Your Ref: FP/10/11/DOC

Article 21 of the Town and Country Planning (General Development Procedure) Order 1995
Application for discharge of conditions 2 & 3 on planning application FP/38/08
Tower House Havelock Close, Bognor Regis,

Garage Layout

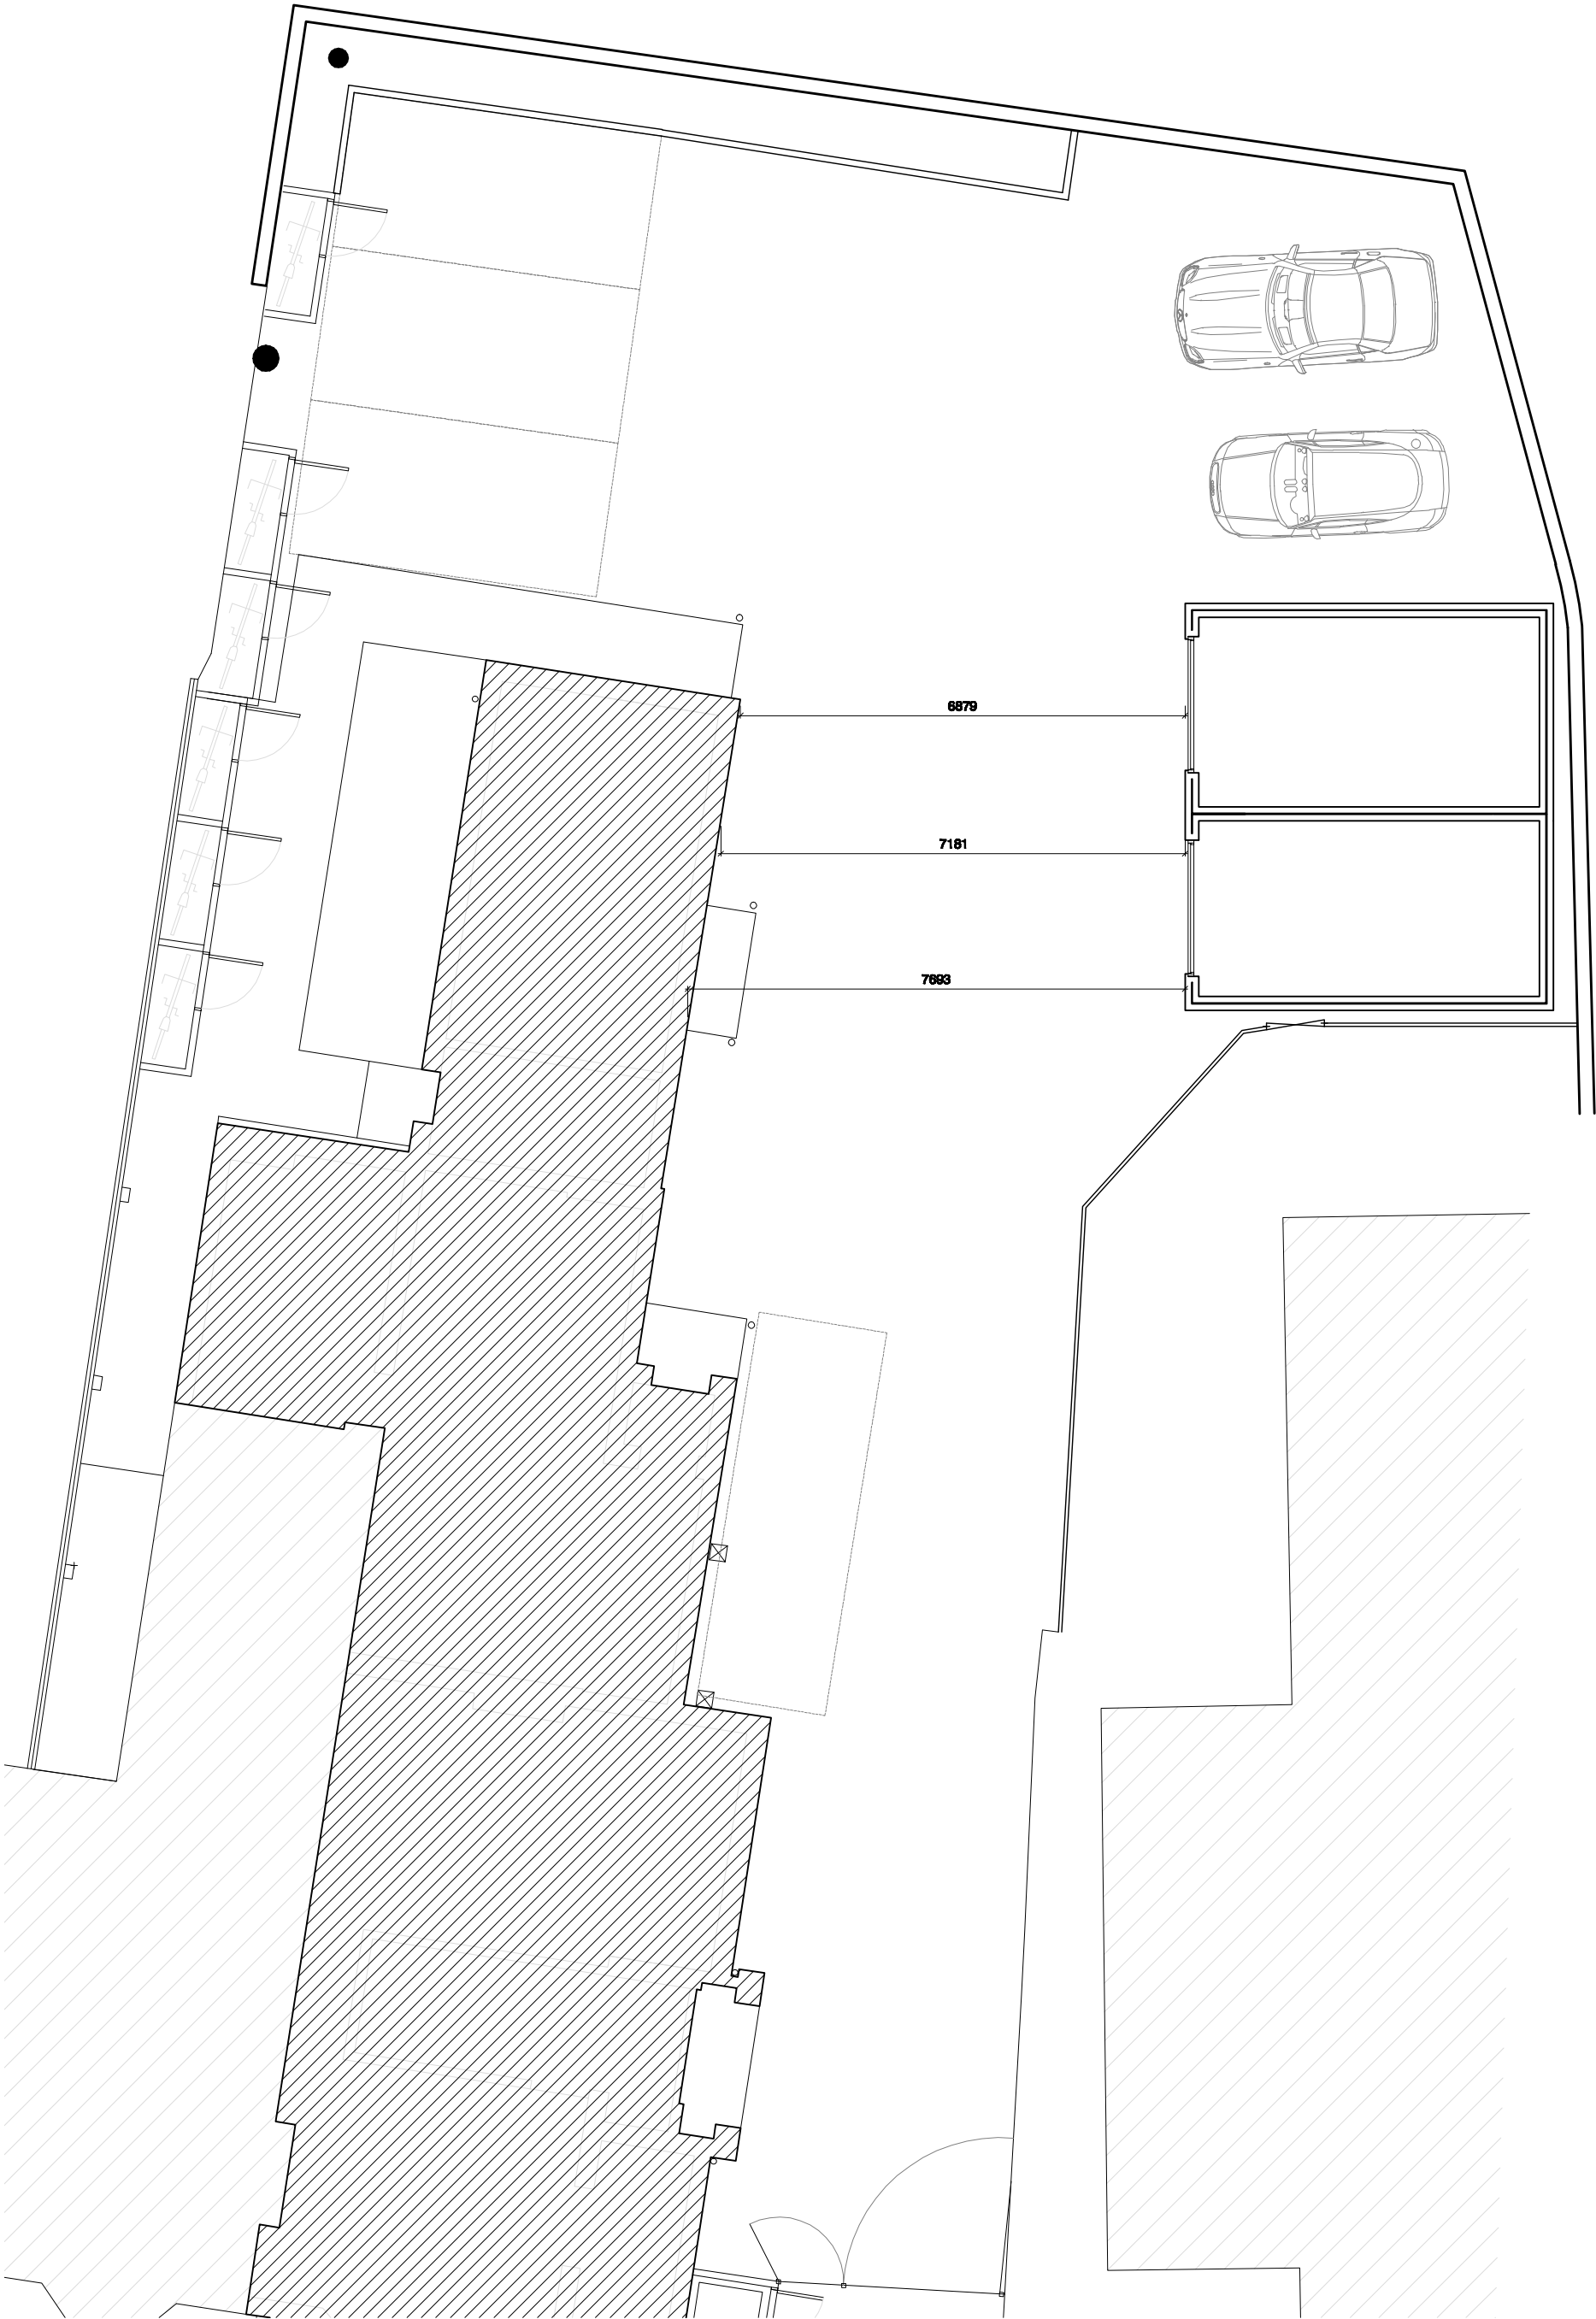
Insufficient detail has been provided to show the covered cycle storage.
